13460  
17 February 2014

**SECTION 96(1A) MODIFICATION APPLICATION - STATE SIGNIFICANT DEVELOPMENT  
APPLICATION NO. SSD-4972  
161 SUSSEX STREET, SYDNEY**

This modification relates to a number of small changes to the approved development that have arisen as a result of further design and engineering development by the project team.

Drawing Title: **SLIP STREET EAST ELEVATION**
Drawing Number: **A-DA-0304**
REV: **H**
Scale: **1:200 @ A0**

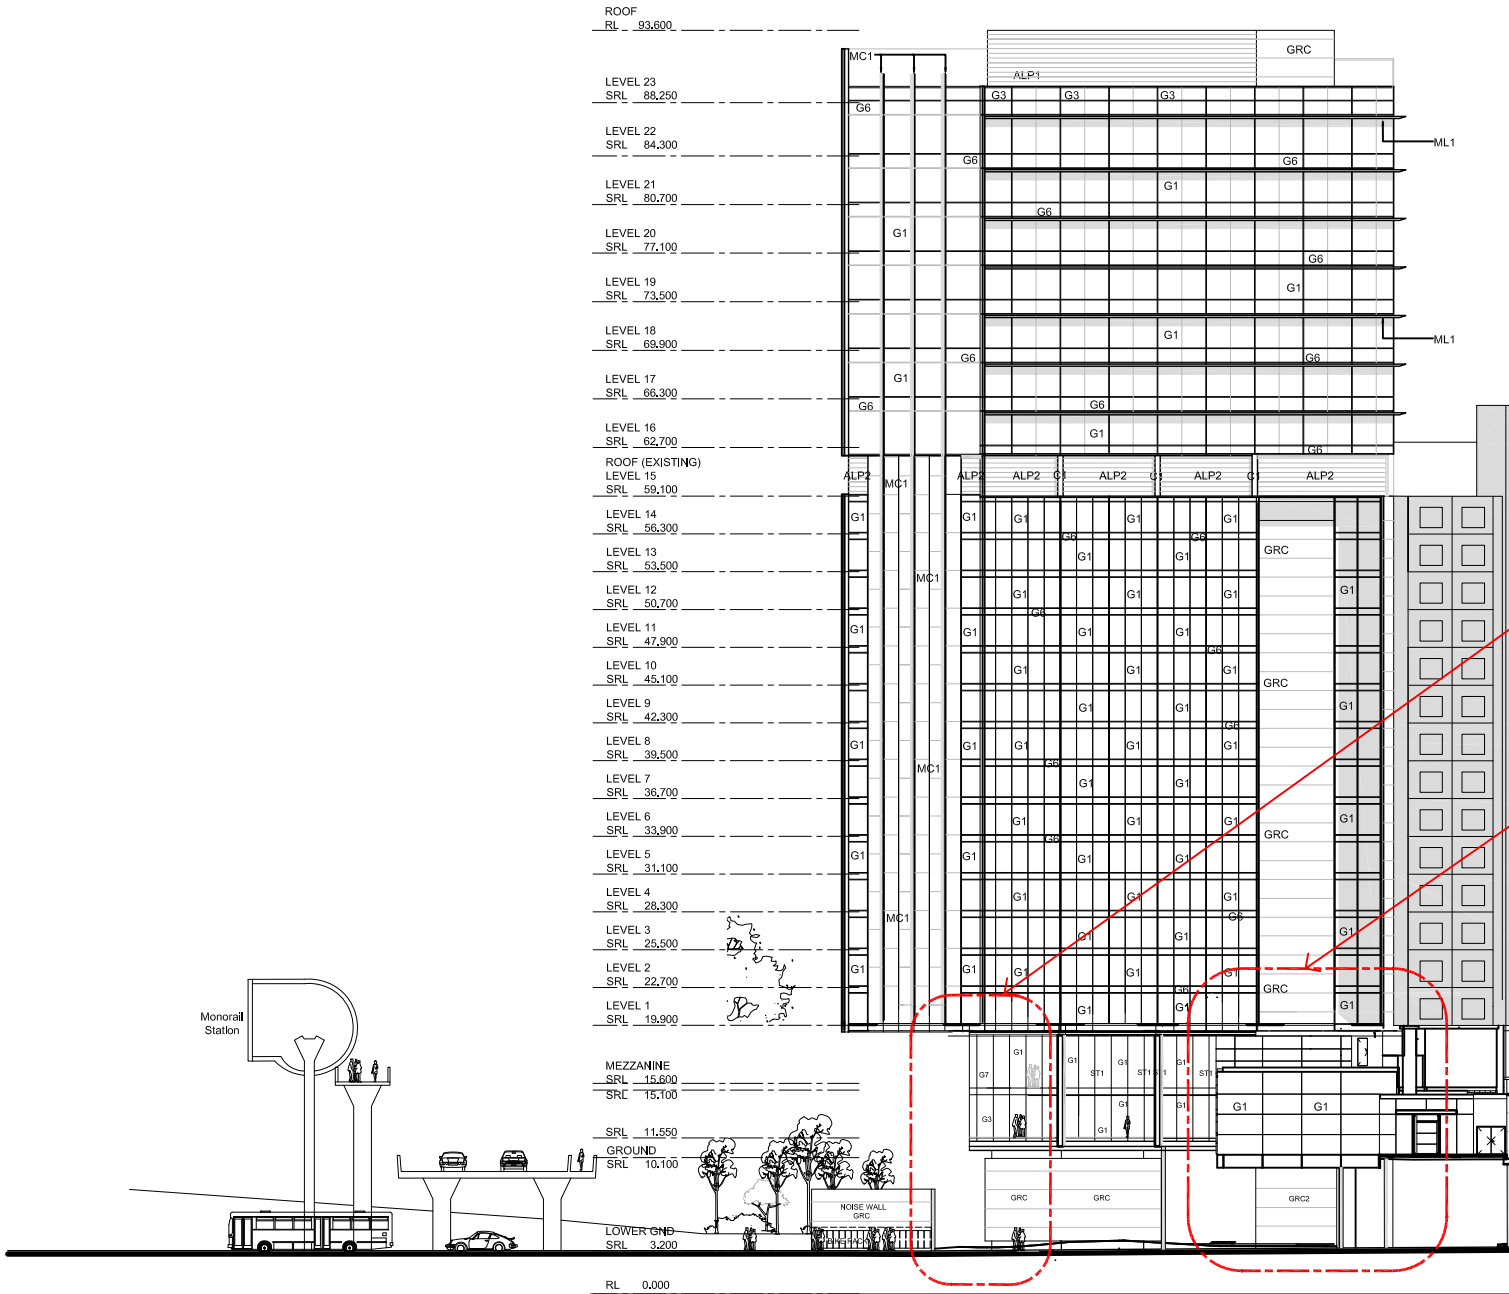
The alignment and configuration of the structural columns, trusses and footings beneath the approved tower have been amended following further design development and testing. The previous angular 'V' columns and trusses have been replaced with a rationalised structural support system that reduces the number and complexity of columns and beams. A comparison between the approved and proposed column configuration is shown in **Figures 1 and 2** and in the accompanying Architectural Plans (**Attachment B**).

It is proposed to amend the approved development by removing a number of existing trees along Slip Lane and located between the approved tower and the Corn Exchange Building. Further detailed design work has identified that a number of electrical pits are required to be provided in this location and as such removal of these trees is necessary. **Figure 4** below between the approved and proposed development.

01 WEST ELEVATION

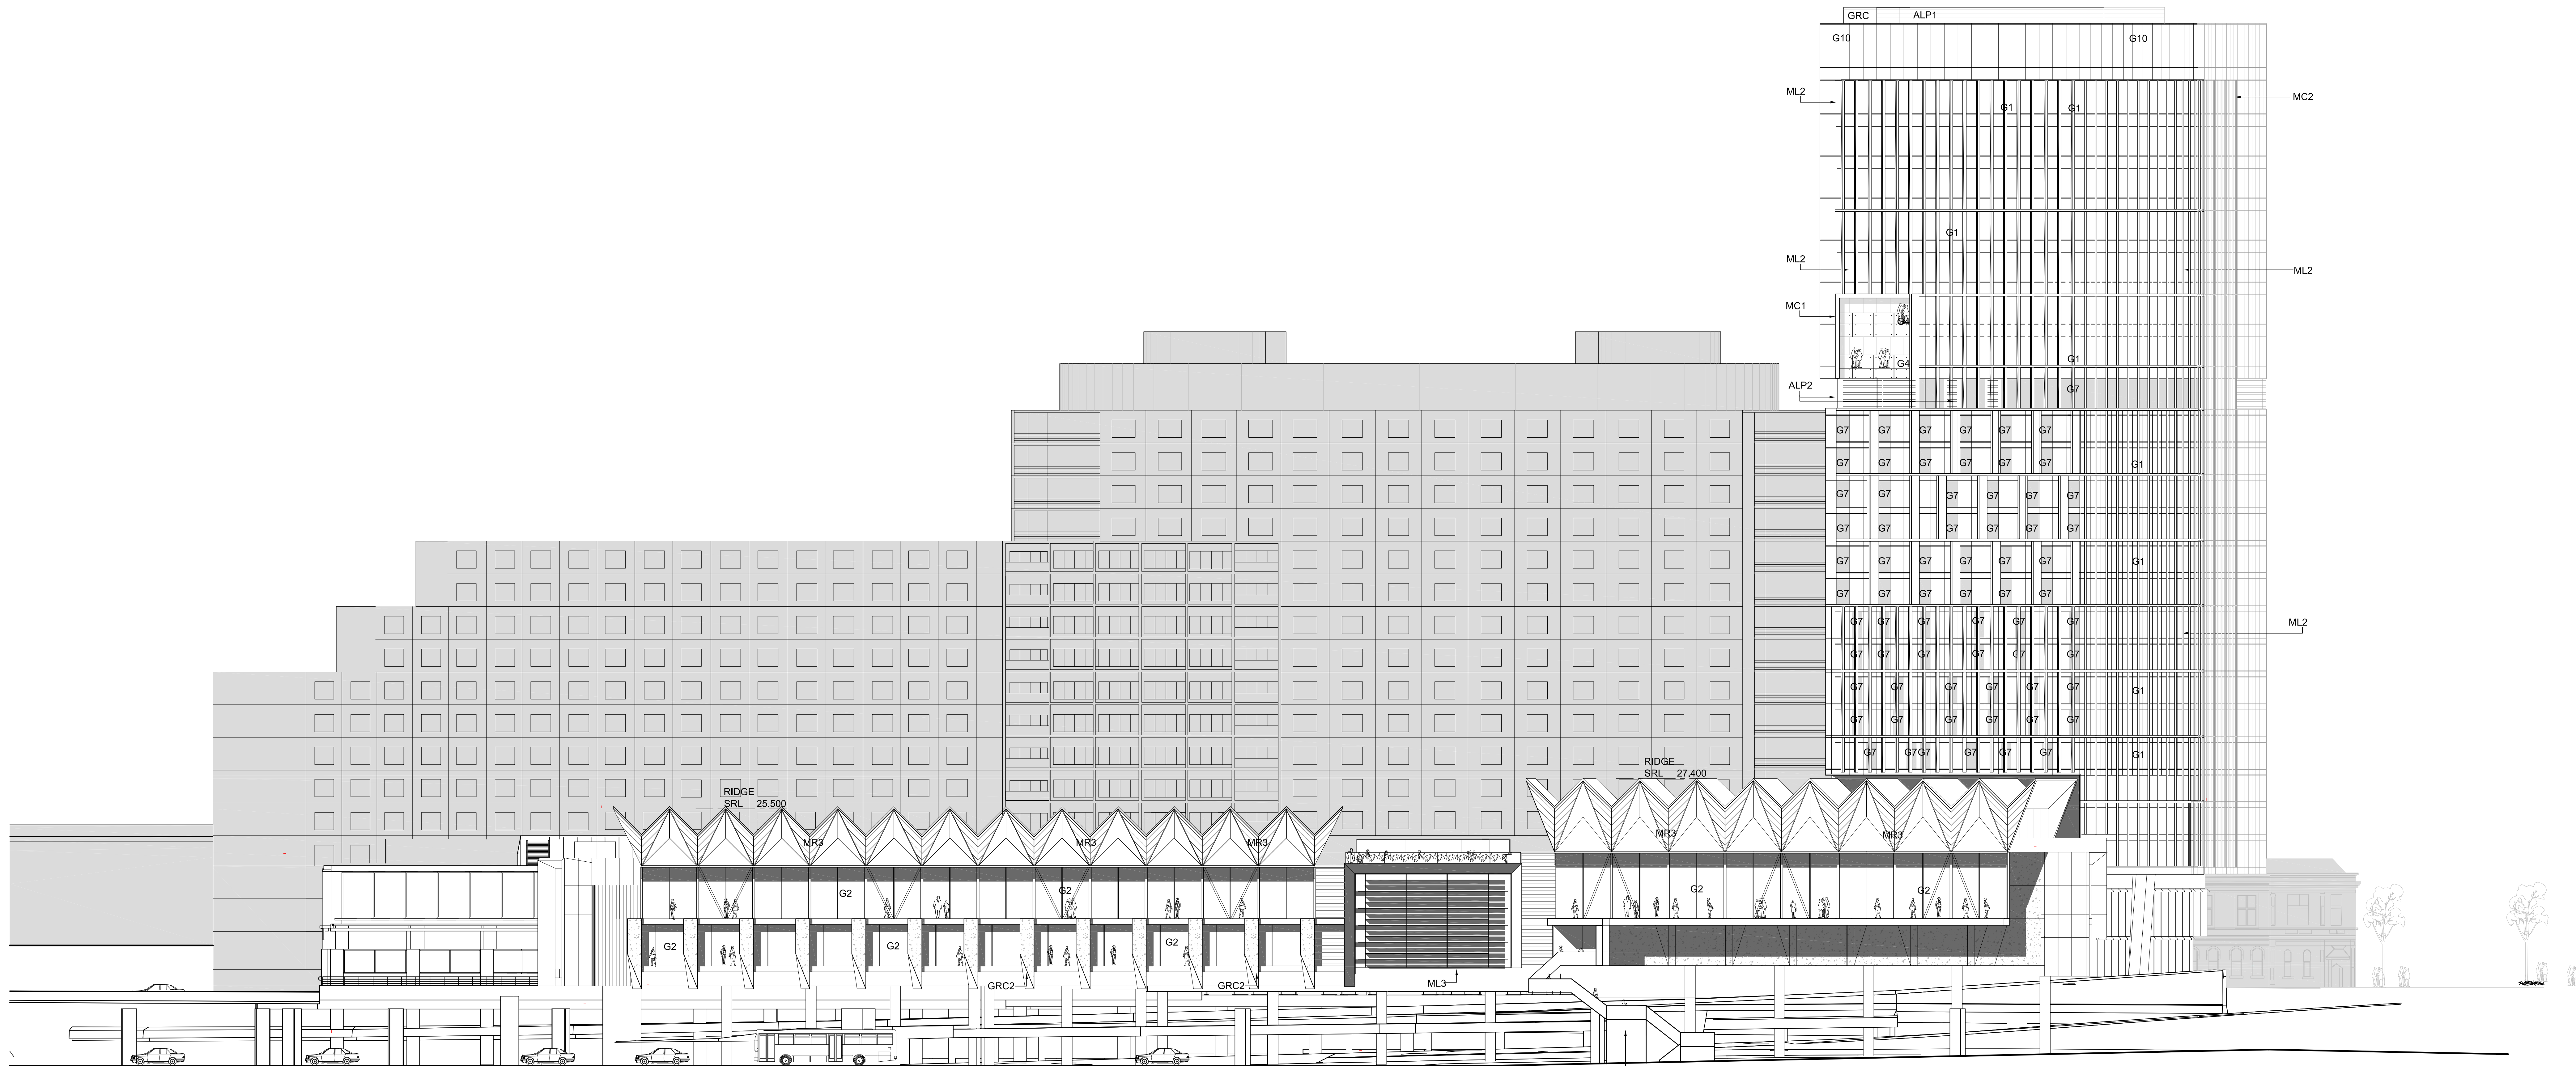
The approved pre-function area situated in the building’s north-west corner has been removed and replaced with a smaller meeting room. The proposed amendment results in some changes to the building’s appearance when viewed from the north and west, however these changes are considered minor and inconsequential in the context of the overall development. Specifically we note that:

- the building façade composition when viewed from the west and north continues to present in a consistent manner to that of the approved development. This is illustrated in **Figures 9 and 10** below;
- the building’s roofline remains consistent with the approved development, of particular note is the iconic sawtooth roof design is unchanged;

Drawing Title: LOWER GROUND LEVEL PLAN																																																																	
Drawing Number: A-DA-0200																																																																	
Scale: 1:200 @ A0																																																																	
0 2 4 6 8 10 20m

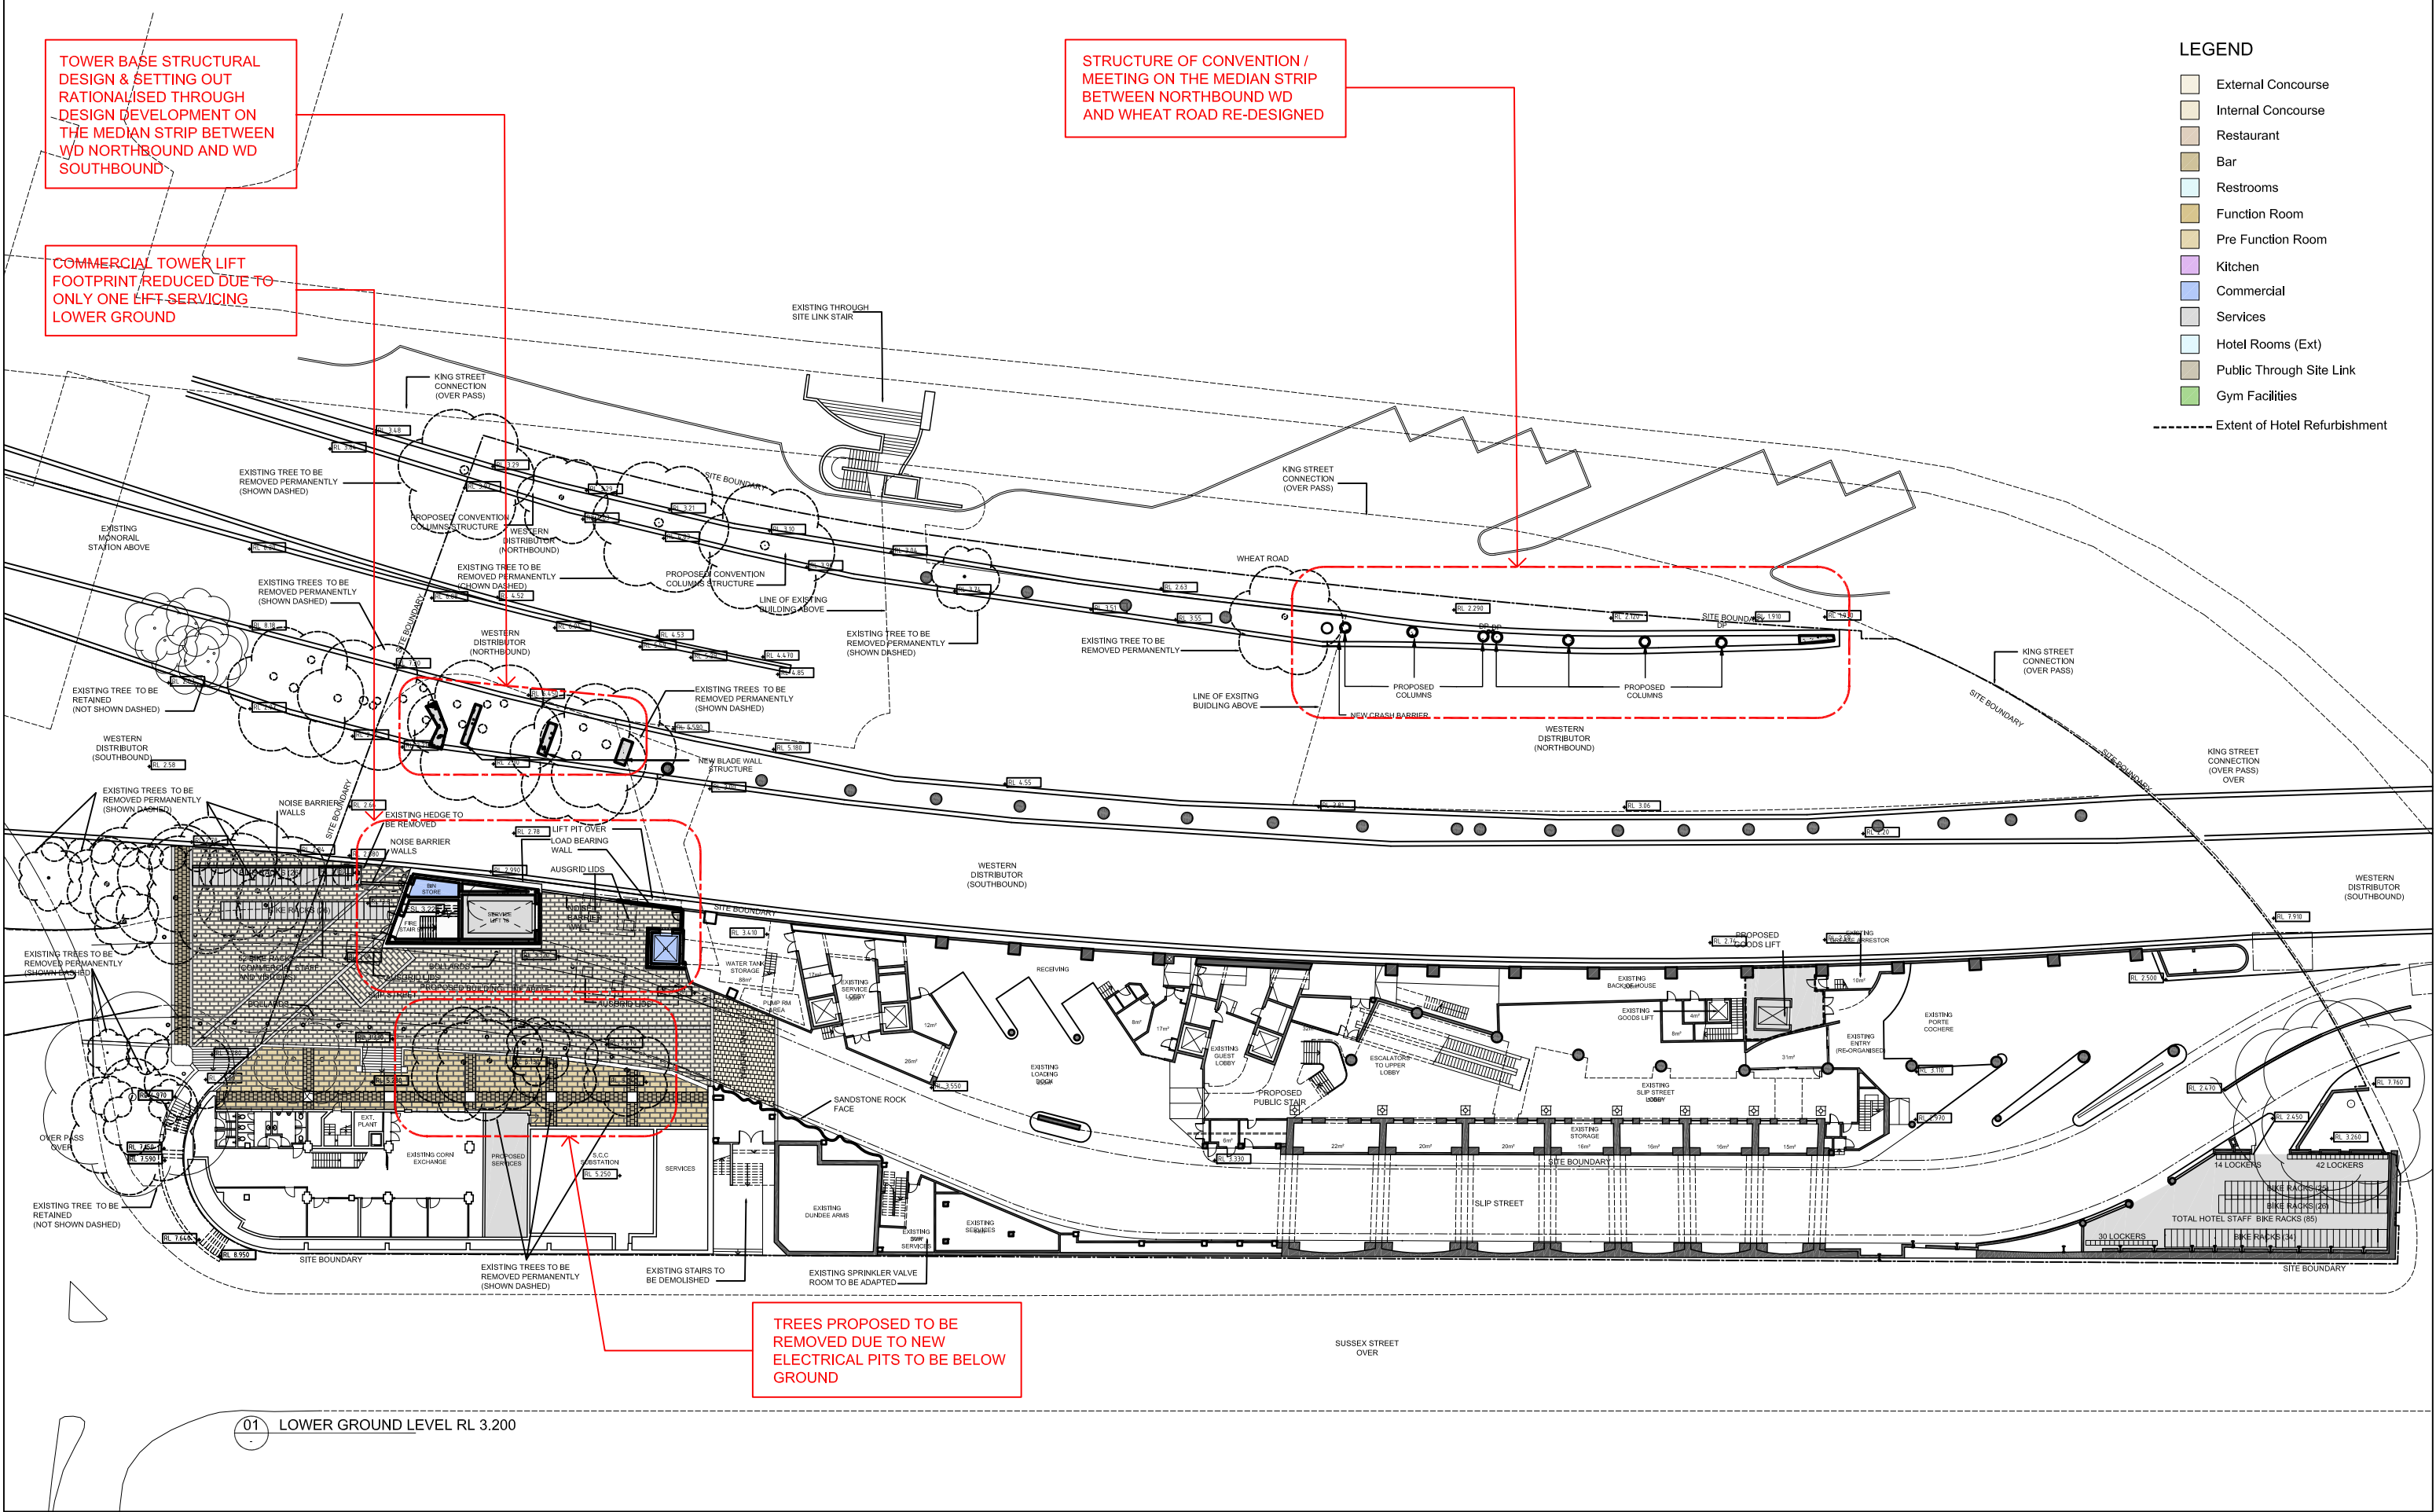
The configuration, location and number of structural columns and footings beneath the approved convention and function space are also proposed to be modified. The number of columns is to be increased from three to eight as shown in **Figure 3** below. The need for these additional columns has been identified following further structural and engineering analysis of the building design. Consistent with the existing approved development, the additional support columns will be located within the median strip between Wheat Road and the northbound lane of the Western Distributor. Further details are provided in the accompanying Architectural Plans (**Attachment B**).
